From: David Hutchison <david.hutchison@pegasusgroup.co.uk>
Sent: 22 December 2023 16:54
To: David Bainbridge; alison.bell@planninginspectorate.gov.uk; Andy Bateson; Katriona Ormiston-Rees; Harry Ramsey; Chris Wentworth; Submit Appeal; james@hubtransportplanning.co.uk; White, Joy - Oxfordshire County Council; davidfrisby@modetransport.co.uk
Subject: Re: APP/C3105/W/23/3326761 - OS Parcel 1570 Adjoining And West Of Chilgrove Drive, And Adjoining And North Of, Camp Road, Heyford Park

I write on behalf of Dorchester Living in response to TN6 prepared by Hub Transport Planning Ltd.

Subject: APP/C3105/W/23/3326761 - OS Parcel 1570 Adjoining And West Of Chilgrove Drive, And Adjoining And North Of, Camp Road, Heyford Park

TITLE  
**REVISED SKETCH SITE ACCESS WITH VISIBILITY SPLAYS AND CALMING**

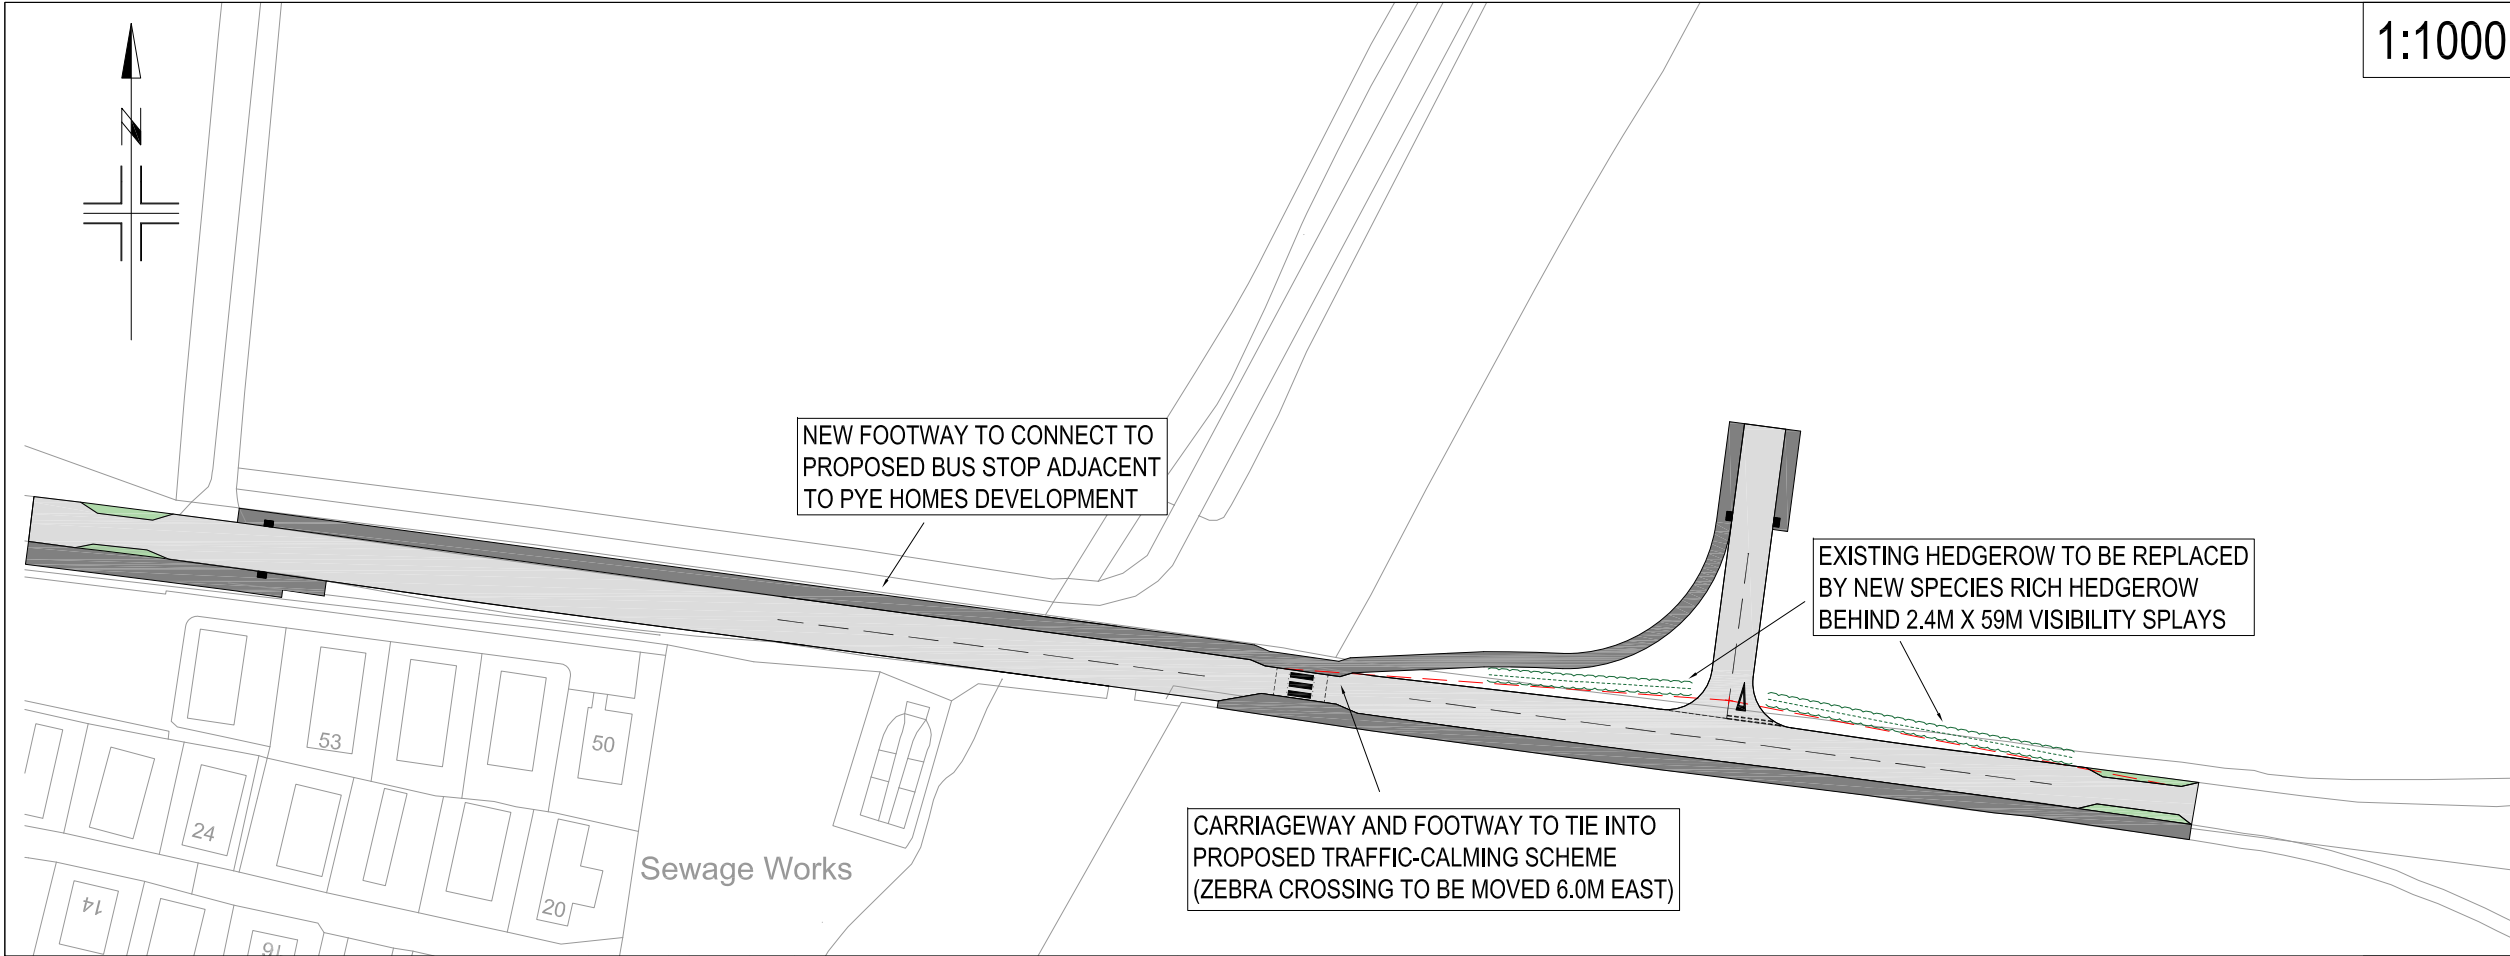
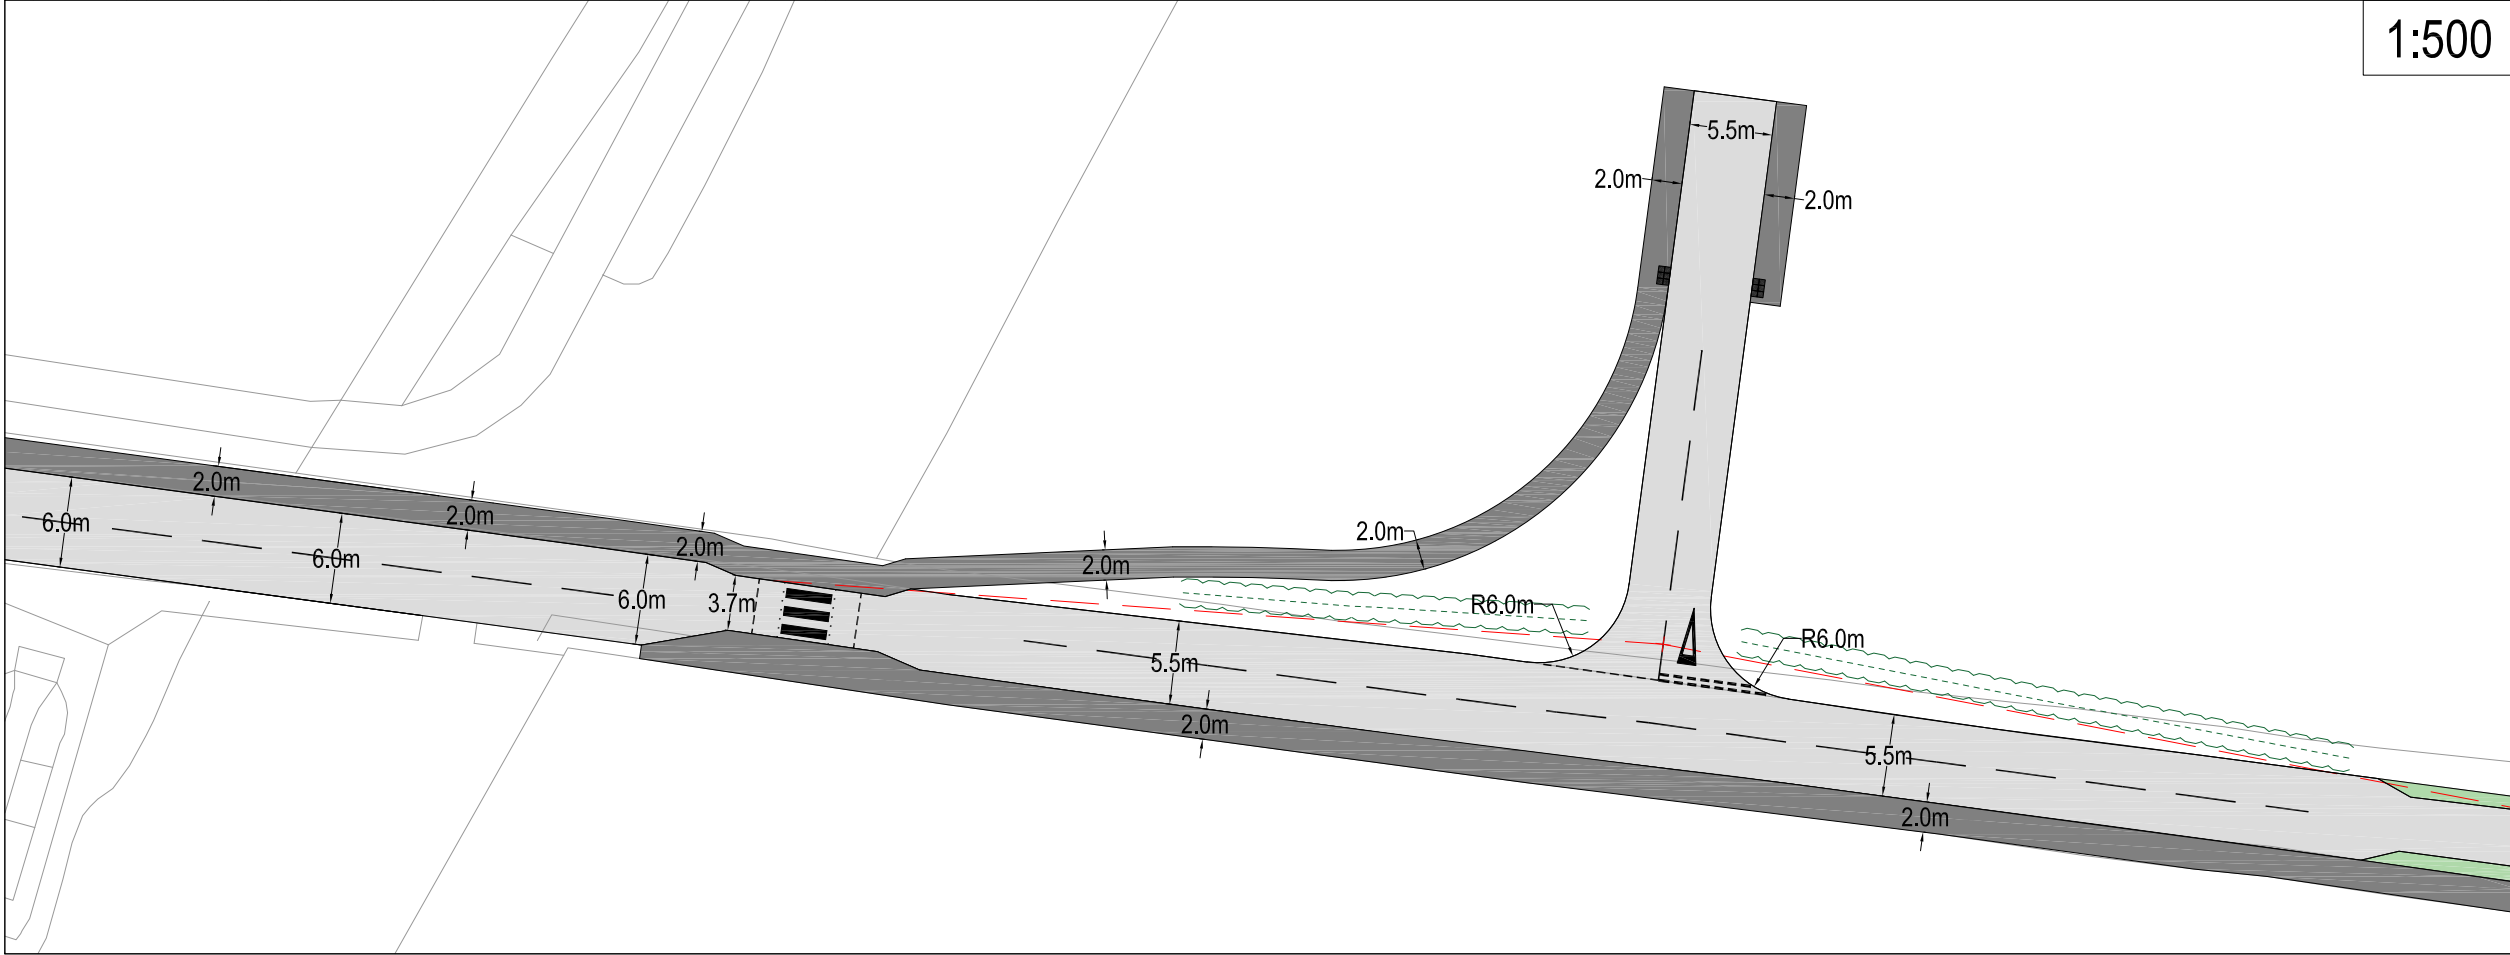
1. It has now become clear through the post inquiry discussions that the Appellants' off-site footpath along Camp Road can only be achieved if:-
 - a. There is a narrowing of the carriageway to 6.0m/6.1m, or

- b. There is a further narrowing of the footpath to 1.7m, 1.8m and 1.9m depending upon location.
2. TN6 remains conspicuously silent on the third option that has not been considered. That is to speak with the adjoining landowners to secure additional land to the north for the footpath (as Pye and BDW have proposed). This would avoid the situation of having a substandard carriageway or a further narrowing of the 2m wide footway.

5. As discussed at the meeting, OCC's own Design Guidance for carriageways on Primary Routes used by buses is 6.75m. This is not referenced in TN6, which proposes a reduction down to 6.0m.

6. We acknowledge that with existing roads it may not always be possible to widen them to achieve this width, but that is not to say that a road width should be reduced below that width. This is particularly true when the Appellants could have avoided this through collaborative working with adjoining landowners (as per the Pye and BDW approach).
